Development Facilitation Team (DFT) – Review Comments

Project No: PR-2022-006568

Project Name: 9200 Wilshire Subdivision

Rehearing of Preliminary Plat – to focus on Retaining and Privacy Walls

DRAWING NO:
LS-101

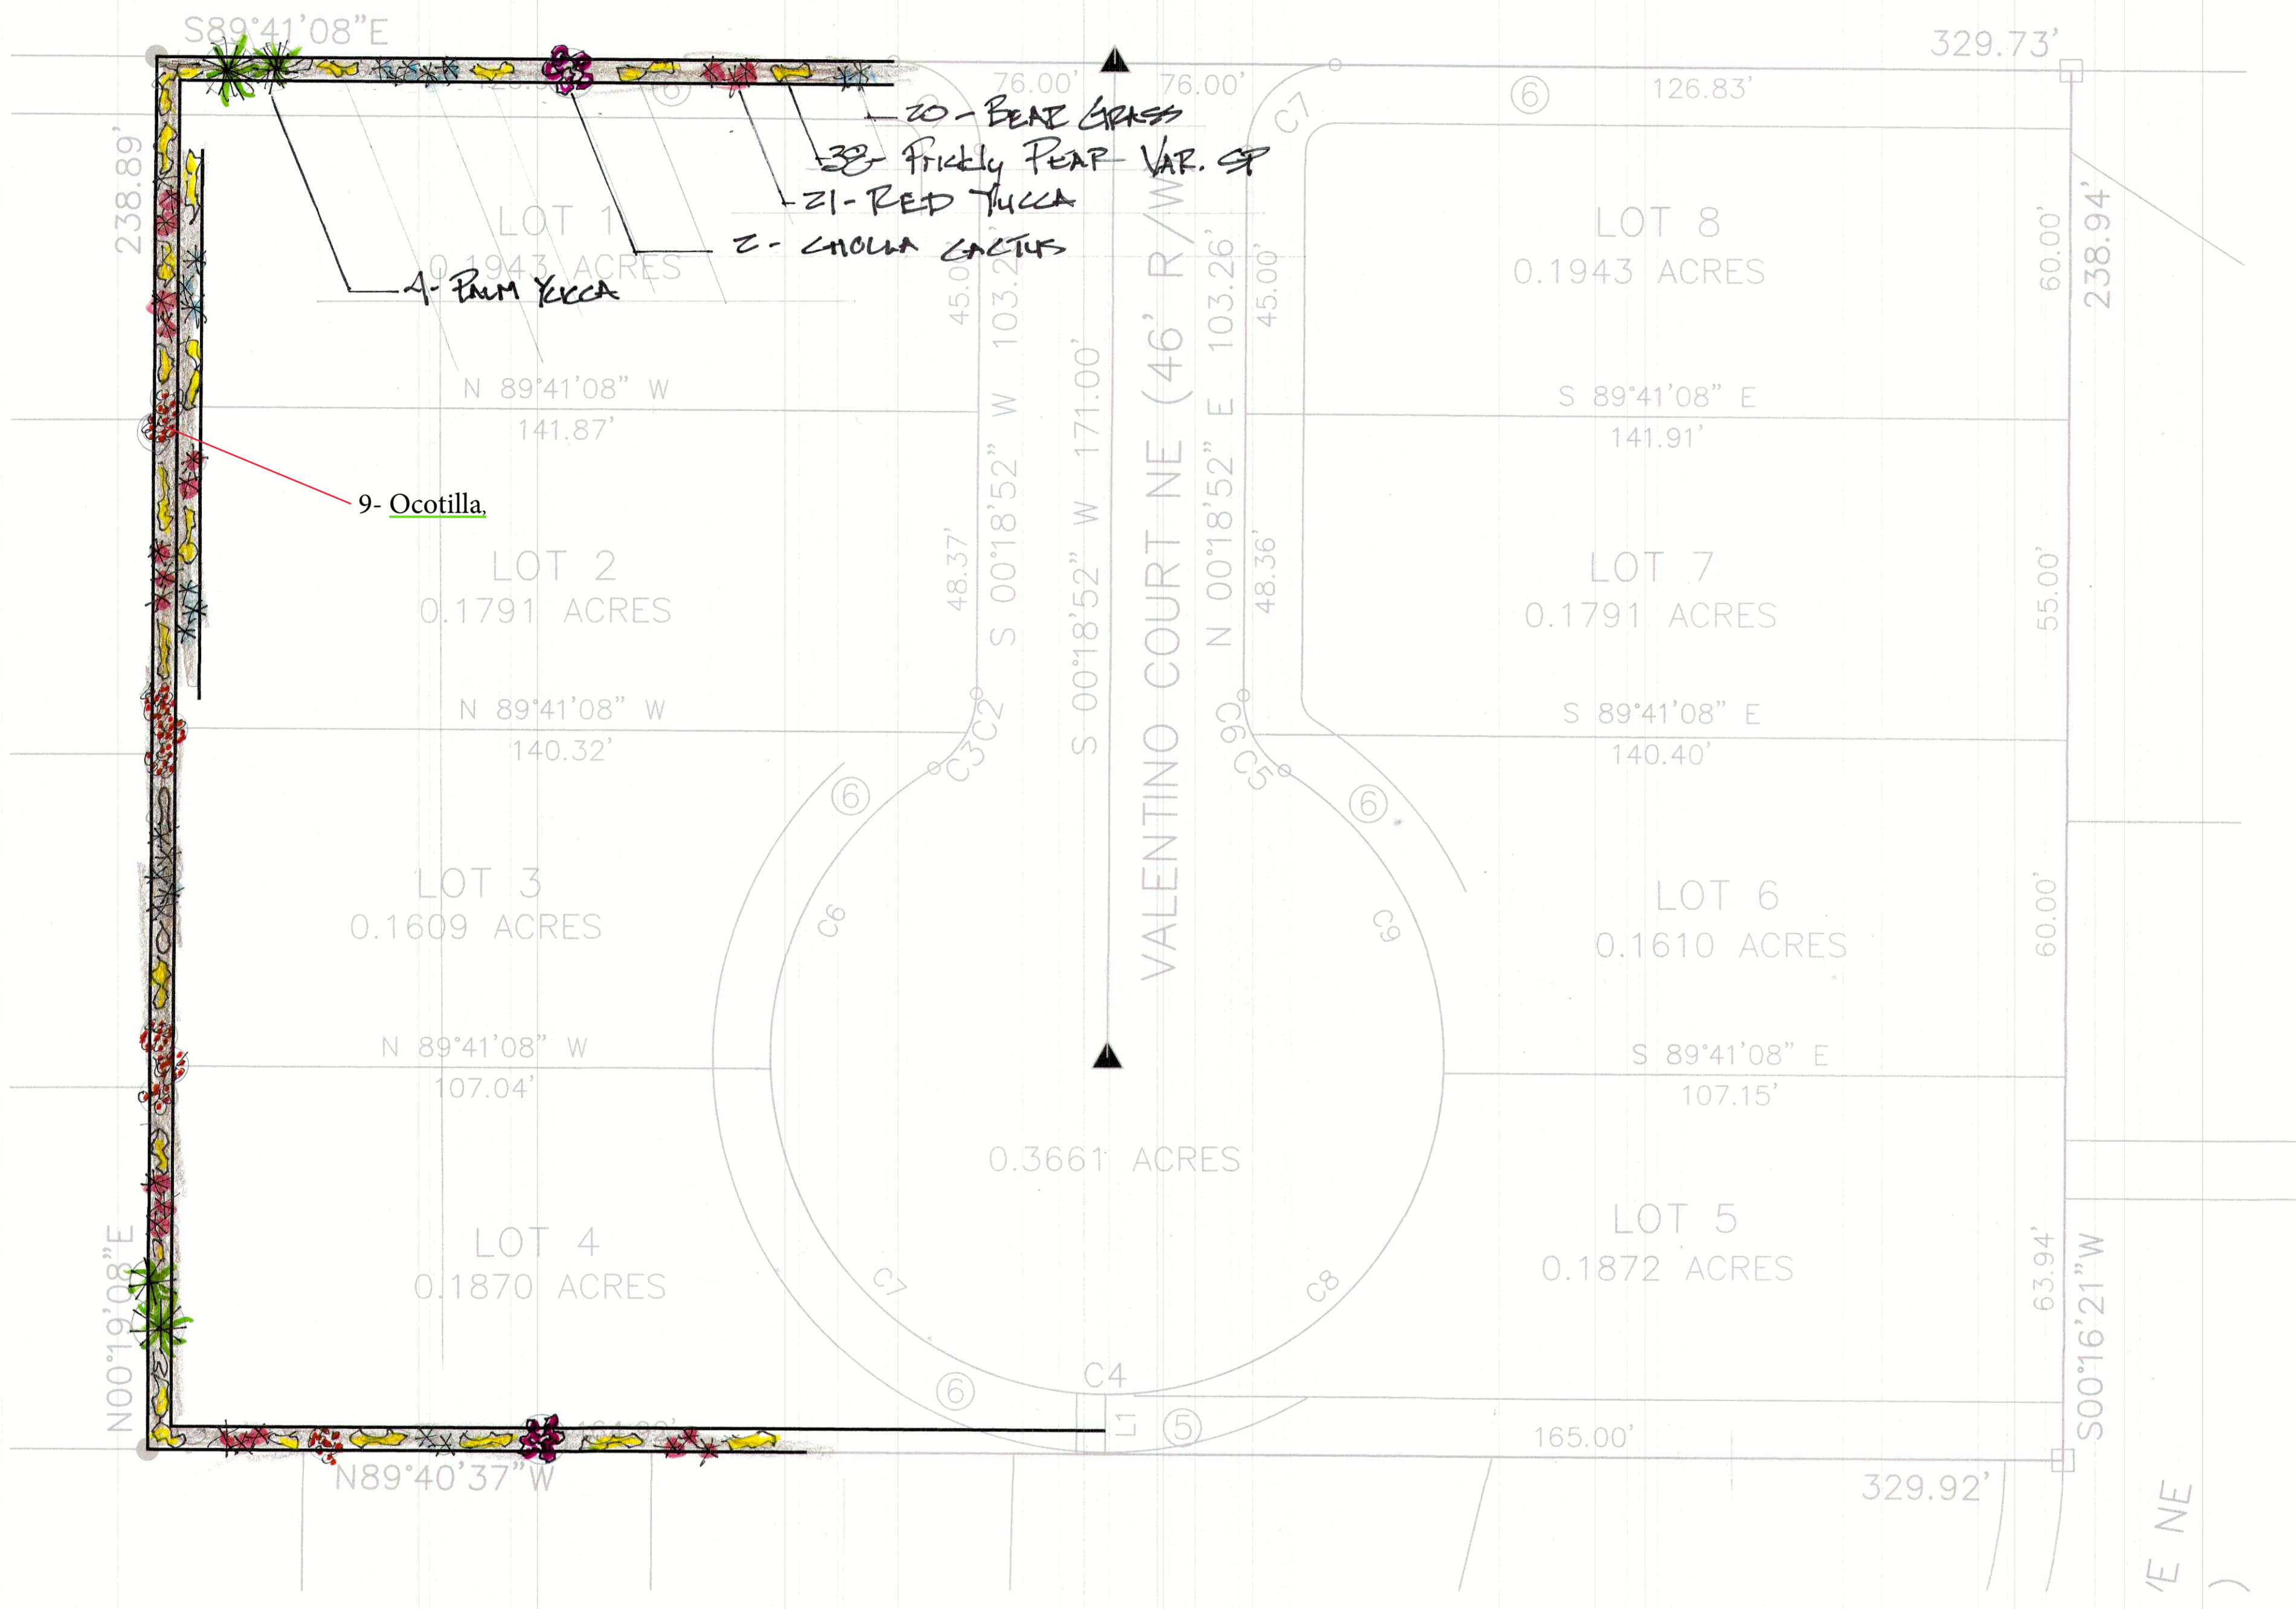
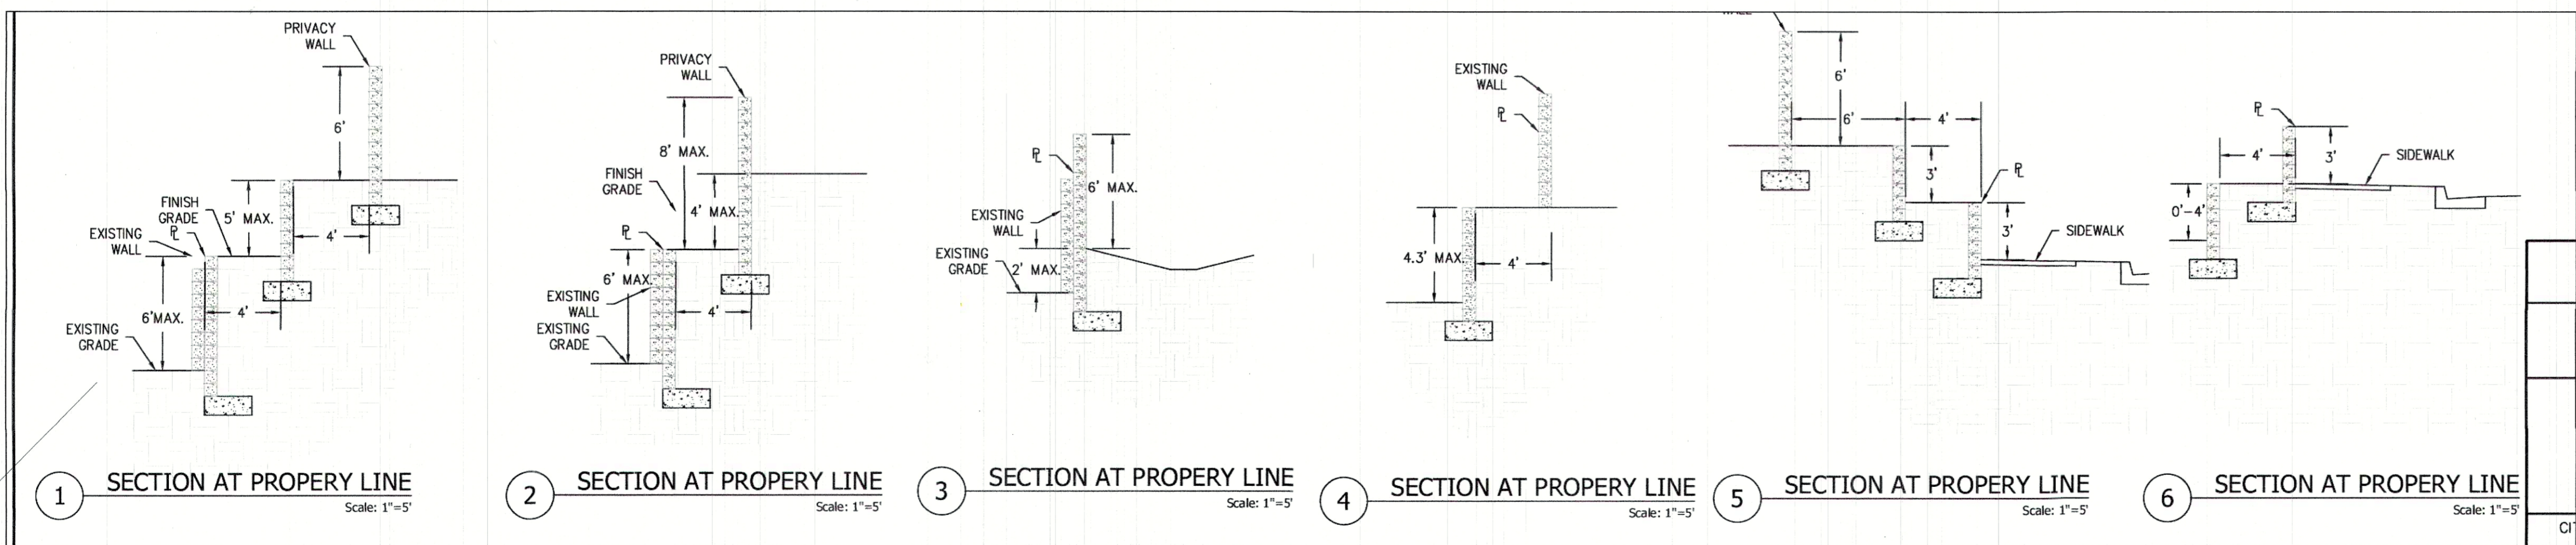
- **Condition #2:** The landscaping exhibit is an approved additional sheet to the plat that will be shared with Code Enforcement as the subdivision builds out. The plant species is to generally follow that submitted, but can be changed with final plat showing additional concurrence between developer and neighbors. The Palm Yucca is to be replaced by Adams Needle (*Yucca filamentosa*).

Plant Palette	Proposed landscaping plan 3/xx/24.	Generally like plants on landscaping plan. Open to changes or amounts.	Suggest replacing Palm Yucca with Adams Needle.	
Safety steel post fence atop retaining wall adjoining existing wall with terraces	Wall exhibit shows the 3.5 foot wall to be added atop the first retaining wall with abutting property	Neighbors requested this feature and generally concur.	Staff concurs.

- 4) The plant palette will work, but staff has concerns regarding the viability of the palm yuccas listed on the graphic. Possibly switch out the palm yucca with a different variety such as Adams Needle (*Yucca filamentosa*). The site design calls for the yuccas to be installed in the terraces of the development which we feel the palm yuccas could become a challenge for the owners to care for due to its large size when fully established.

- 5) The developer made a note in the landscape drawing that says: "All dead and dying plants shall be replaced annually". How long does the developer intend to fulfill this promise? As it reads currently this would be the equivalent of a lifetime warranty and they would be expected to deliver and install the plants at no cost to the owner. This alone will be more expensive over time and less cost effective than if the developer installs irrigation and provides a 1–2-year warranty for the plants while they establish.
